[REDACTED]
Sent: 09 March 2017 10:37
To: Planning.Responses
Subject: Site: Cinders Nursery & Land R/O Cinders Lane, Yapton, BN18 0JJ.

Y/5/17/OUT

PLAN-017235

Proposal: Outline application for 51no. dwellings with all matters reserved except for access. This application is a Departure from the Development Plan.
Site: Cinders Nursery & Land R/O Cinders Lane, Yapton, BN18 0JJ.
Y/5/17/OUT

GENERAL ARRANGEMENT – SITE ACCESS ROAD (SCALE 1:500)

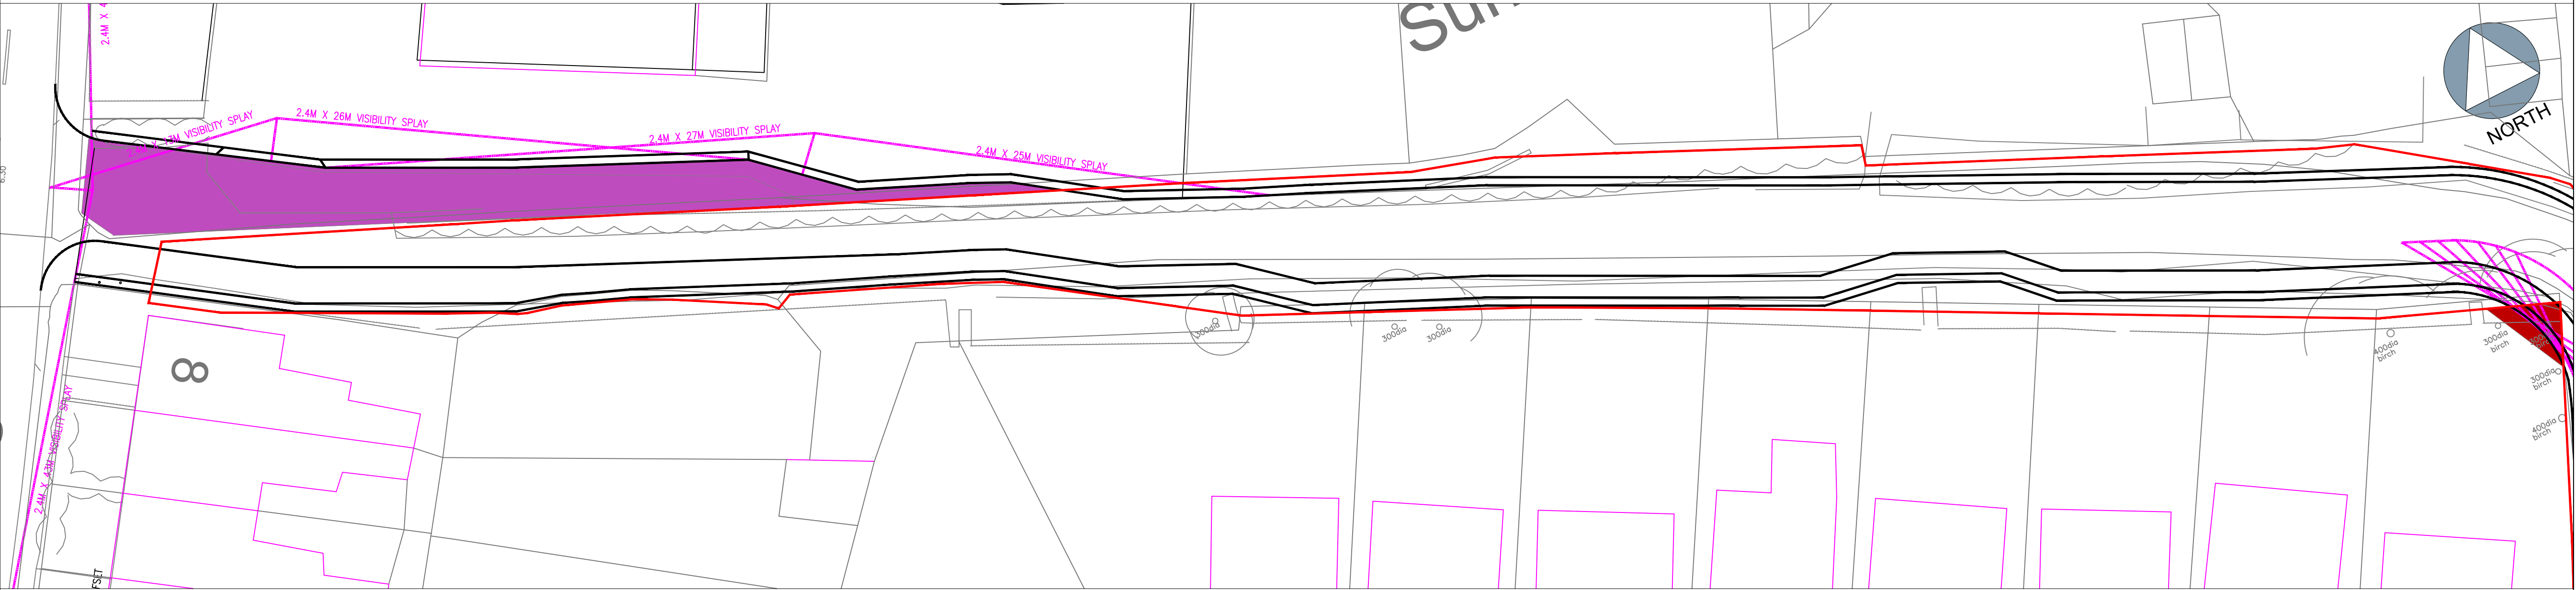
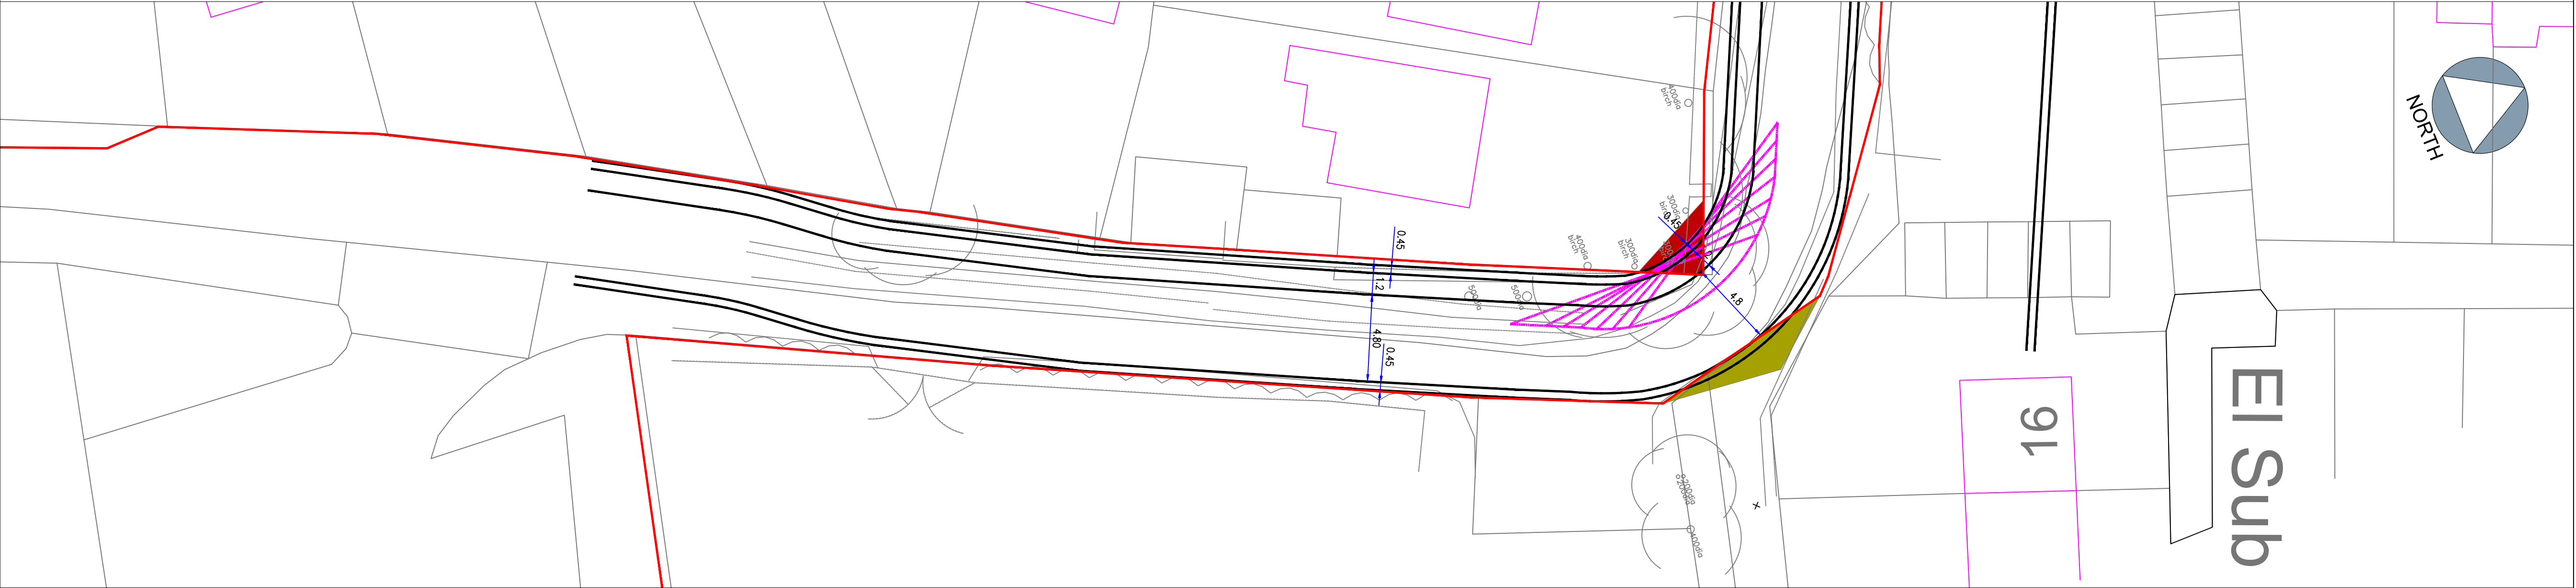
Please find attached a plan of the sewer records showing the approximate position of foul sewer within the access of the site. The exact position of the foul sewers must be determined on site by the applicant before the layout of the proposed development is finalised.

- No development or new tree planting should be located within 3 metres either side of the centreline of the foul sewer.
- No new soakaways should be located within 5m of a public sewer.
- All existing infrastructure should be protected during the course of construction works.

Any works within highway/ access road will require to protect public apparatus and the protection details need to be submitted to, and approved by Southern Water under NRSWA enquiry.
